# DRAINAGE LETTER

## 7280 N. NEVADA LANE

PCD File: PPR2411

SUBJECT: Drainage Letter, 7280 N. Nevada Lane

7280 NEVADA LANE  
AREA DRAINAGE MAP  
1"=60'

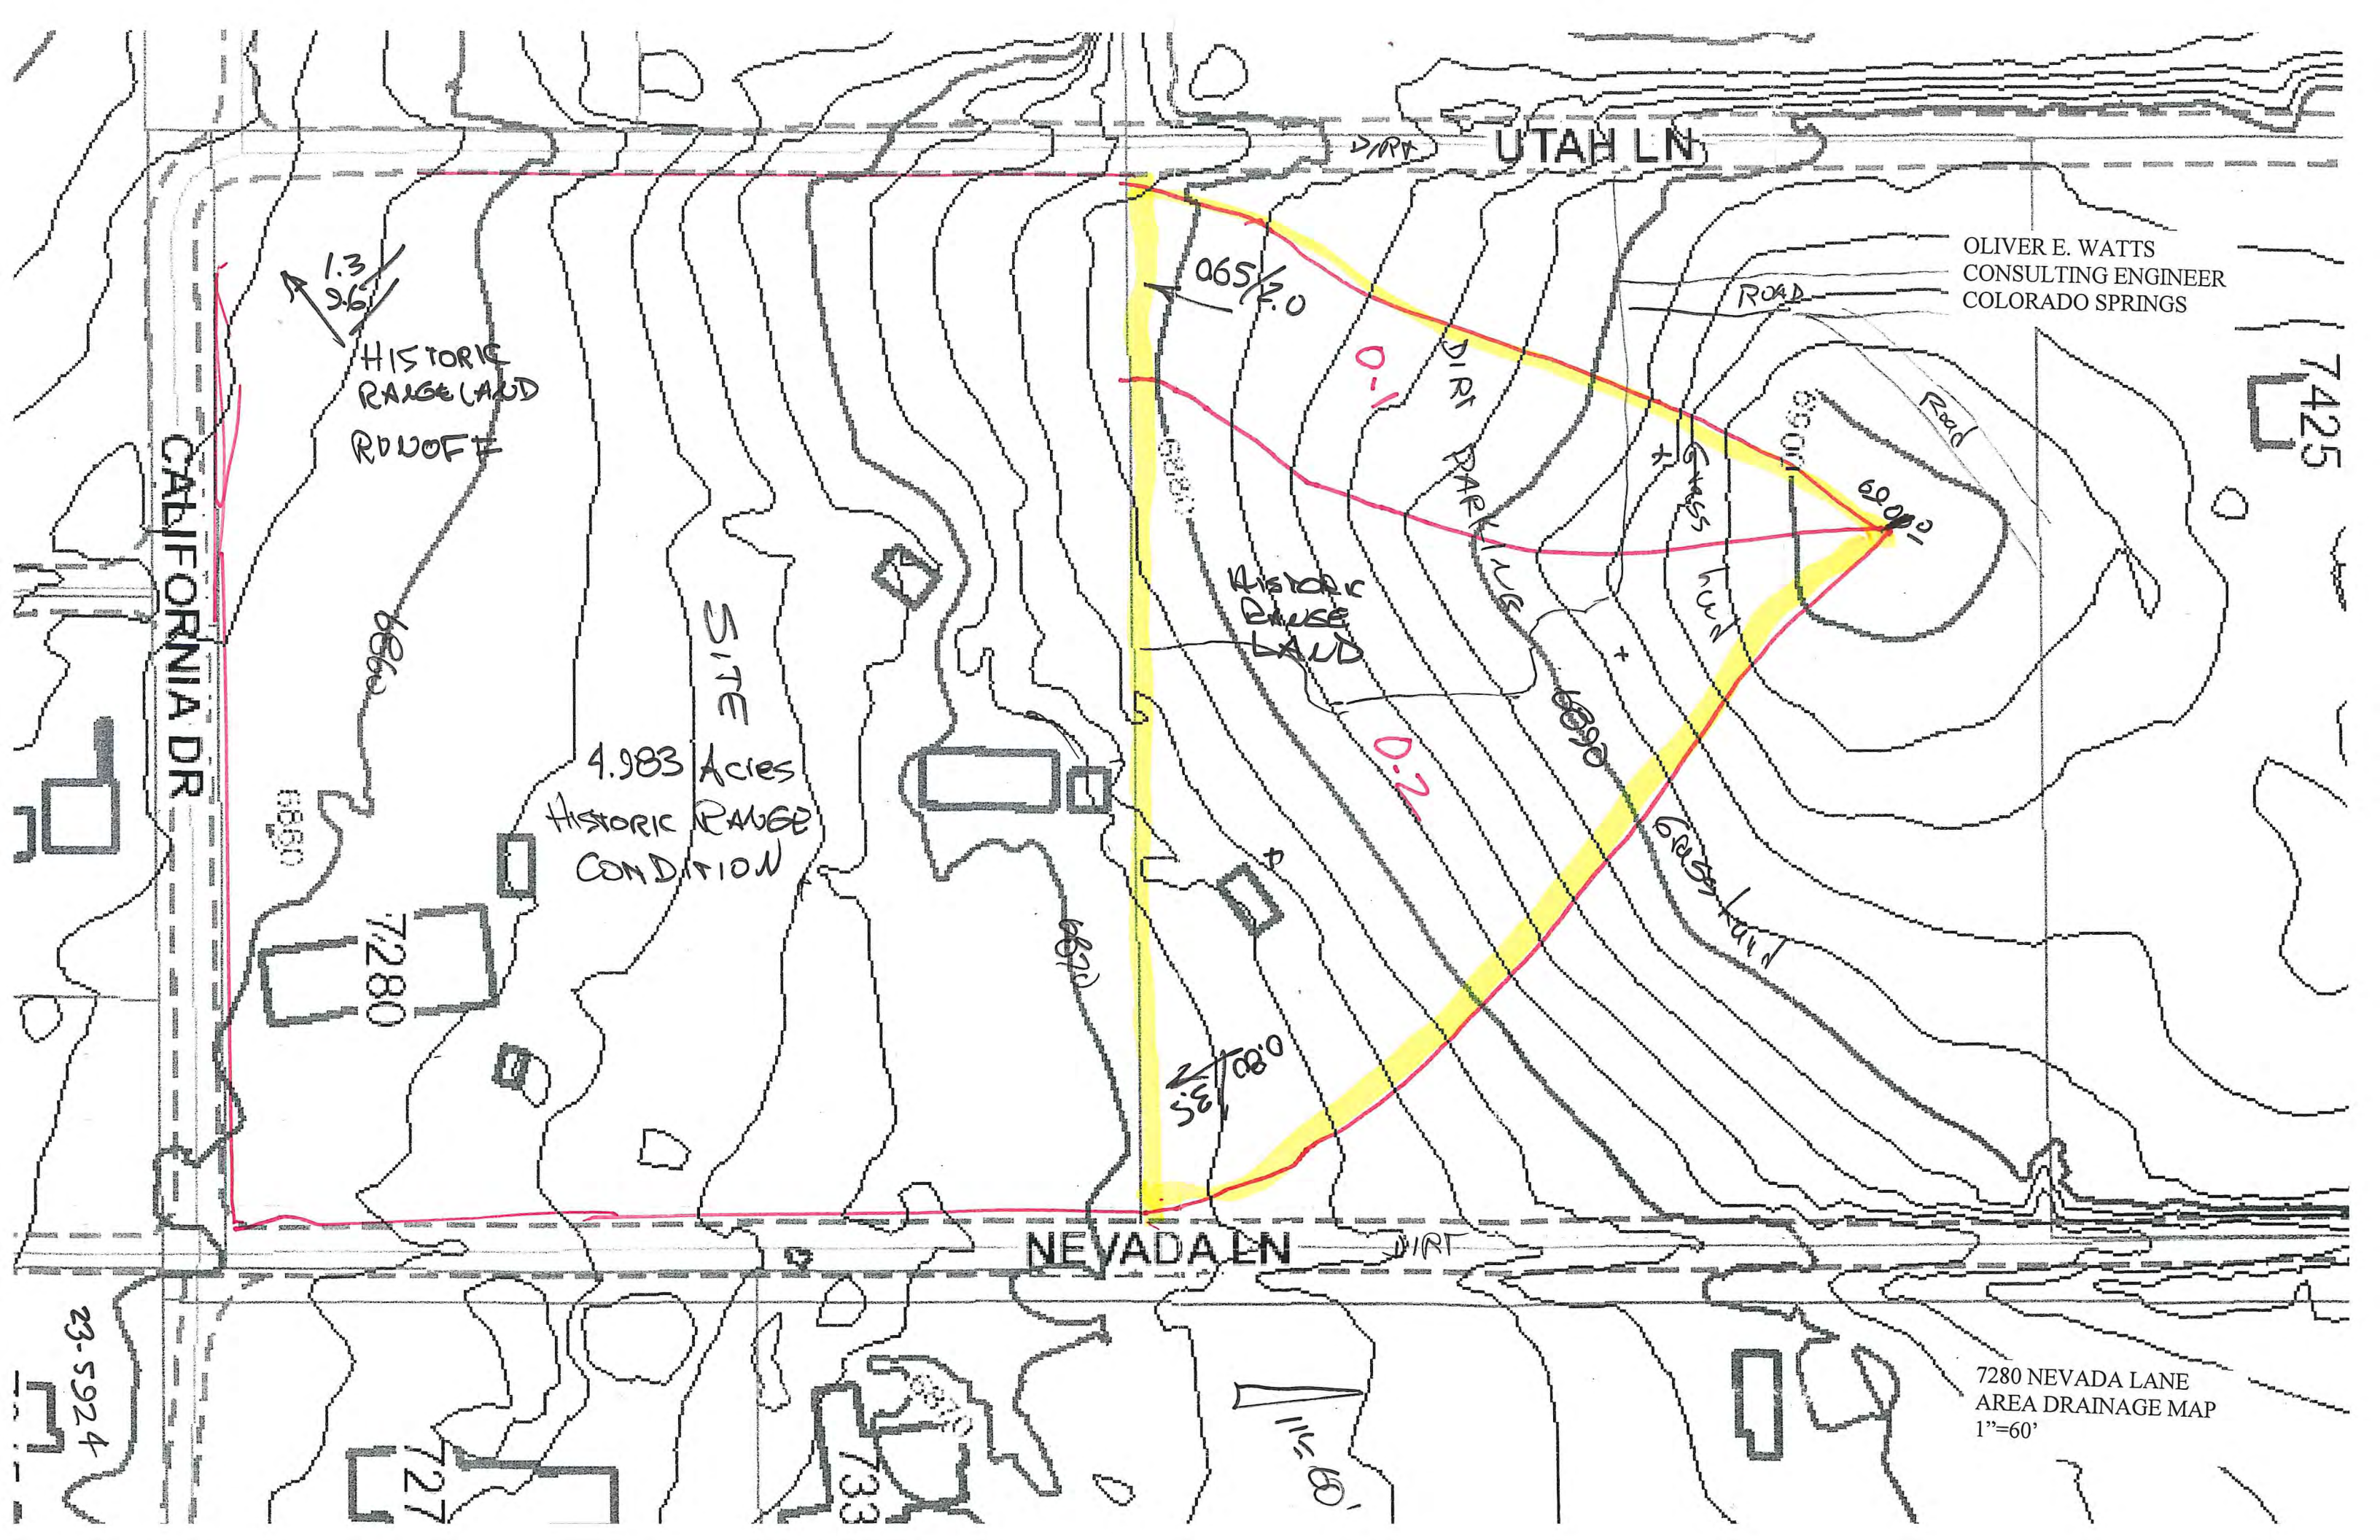
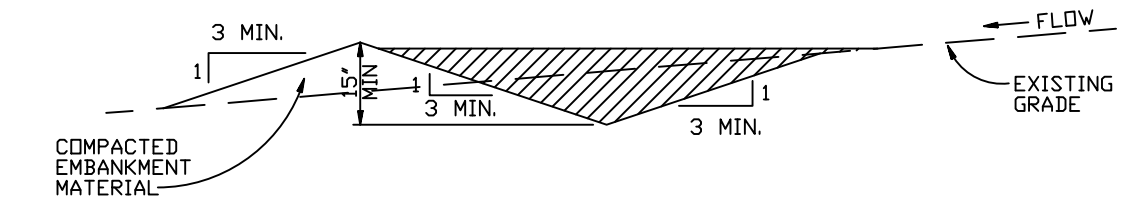
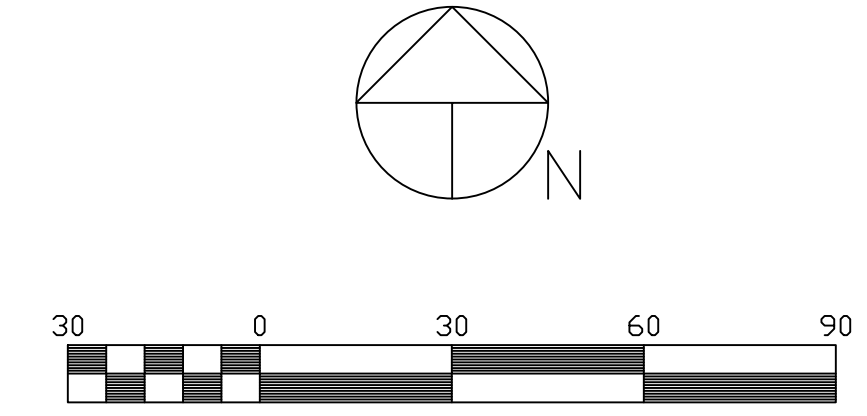
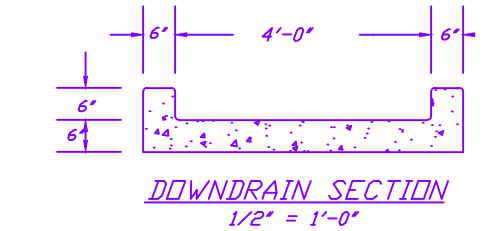
A concentrated flow into the pond directly is discouraged due to erosion.

What form of dissipation is provided at the discharge points? Please show and label it on the drainage map.

Erosion protection is required at the outfall pipe such as a level spreader. Note that concentrated discharge directly onto California Dr. - the dirt roadway can cause erosion.

DRAWN BY: D.E. WATTS
 DATE: 11-2-23
 DWG. NO.: 23-5924-04

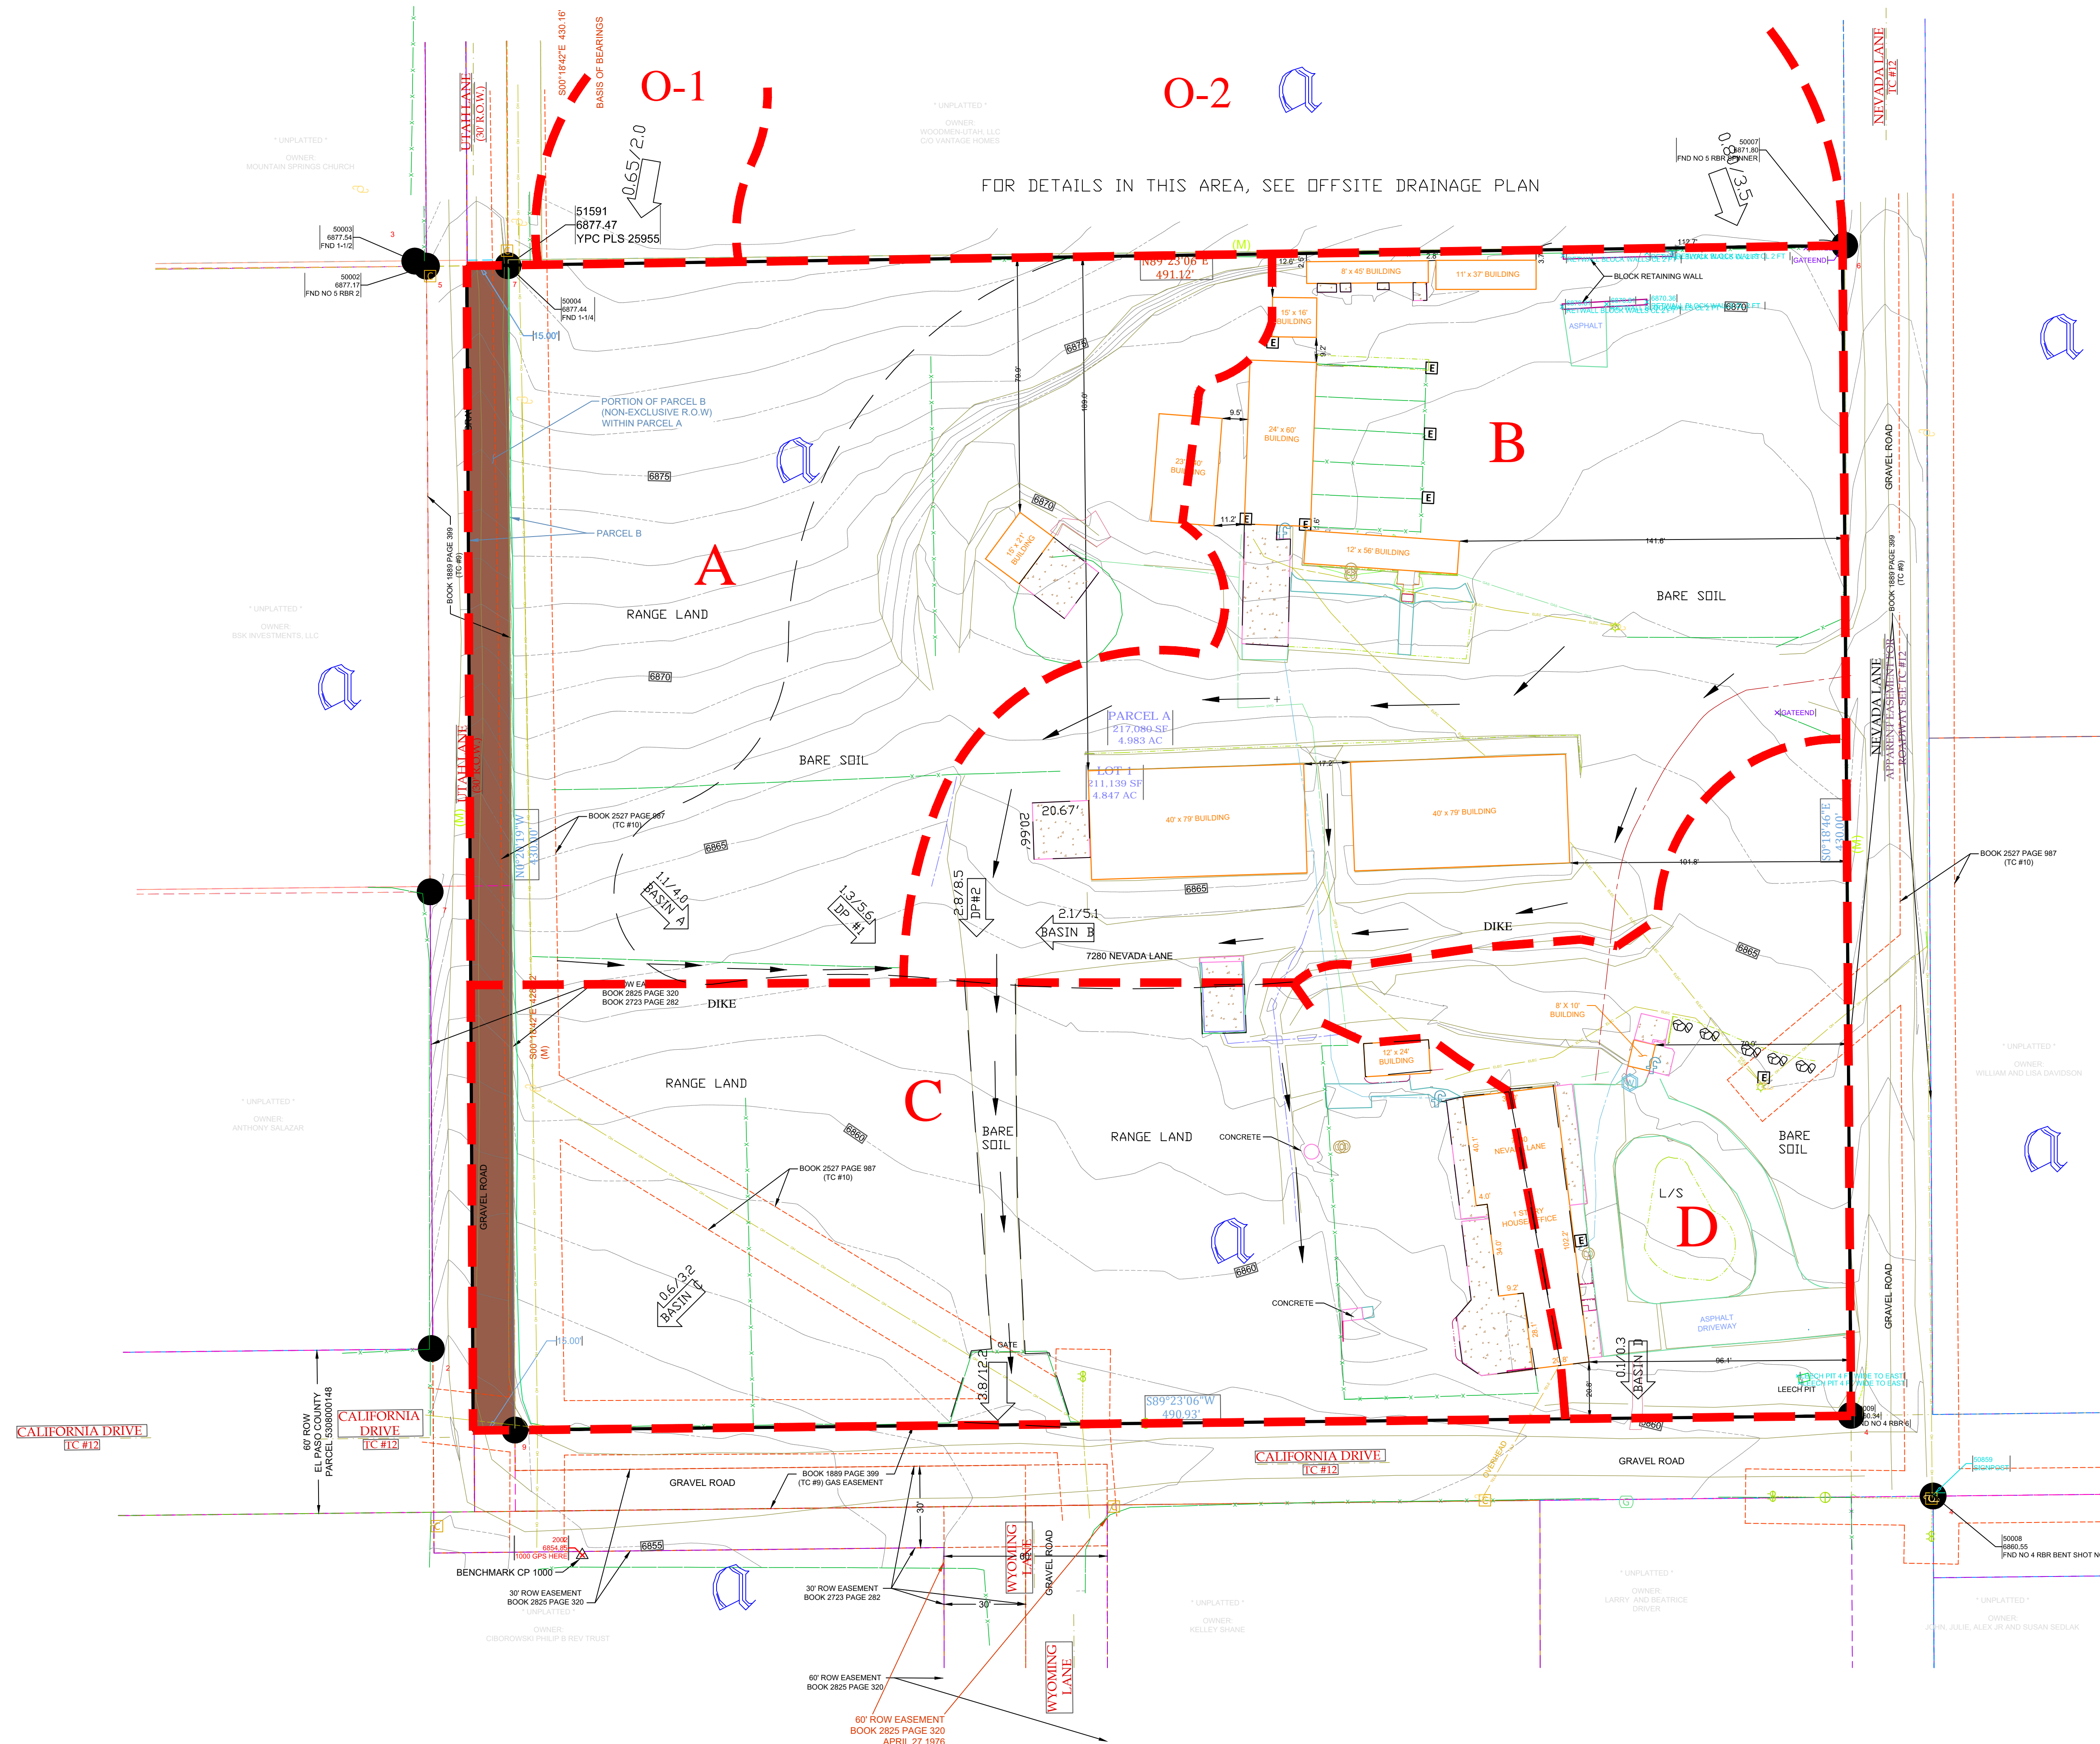
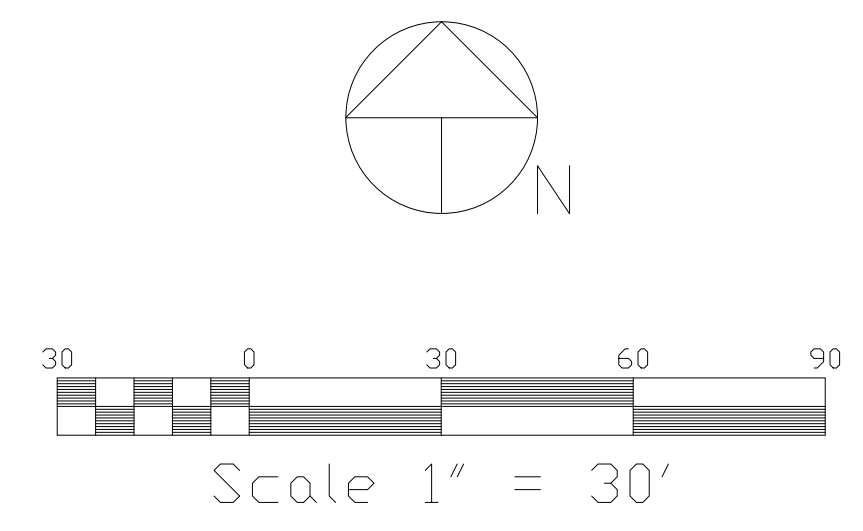
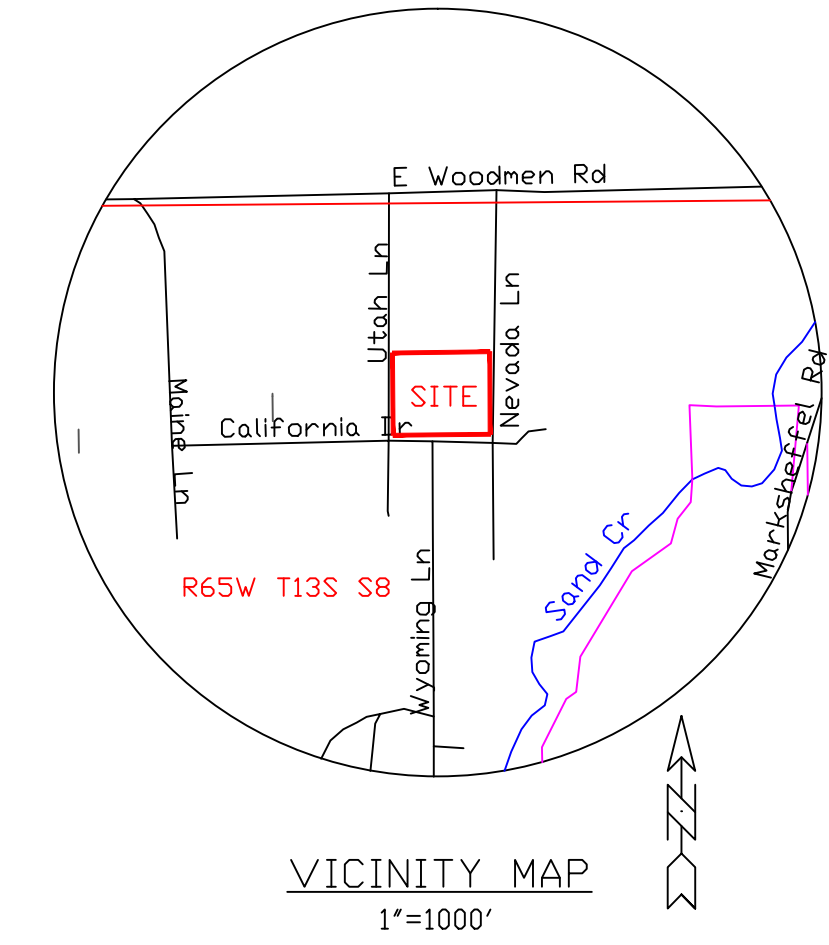
Review C2: Unresolved. Although this project disturbed more than 1 acre, since it has already been built out, GEC is not needed, but construction drawings for the detention pond and outlet structures are required

I cannot review these pond calcs without pond details. Please provide construction details for pond.
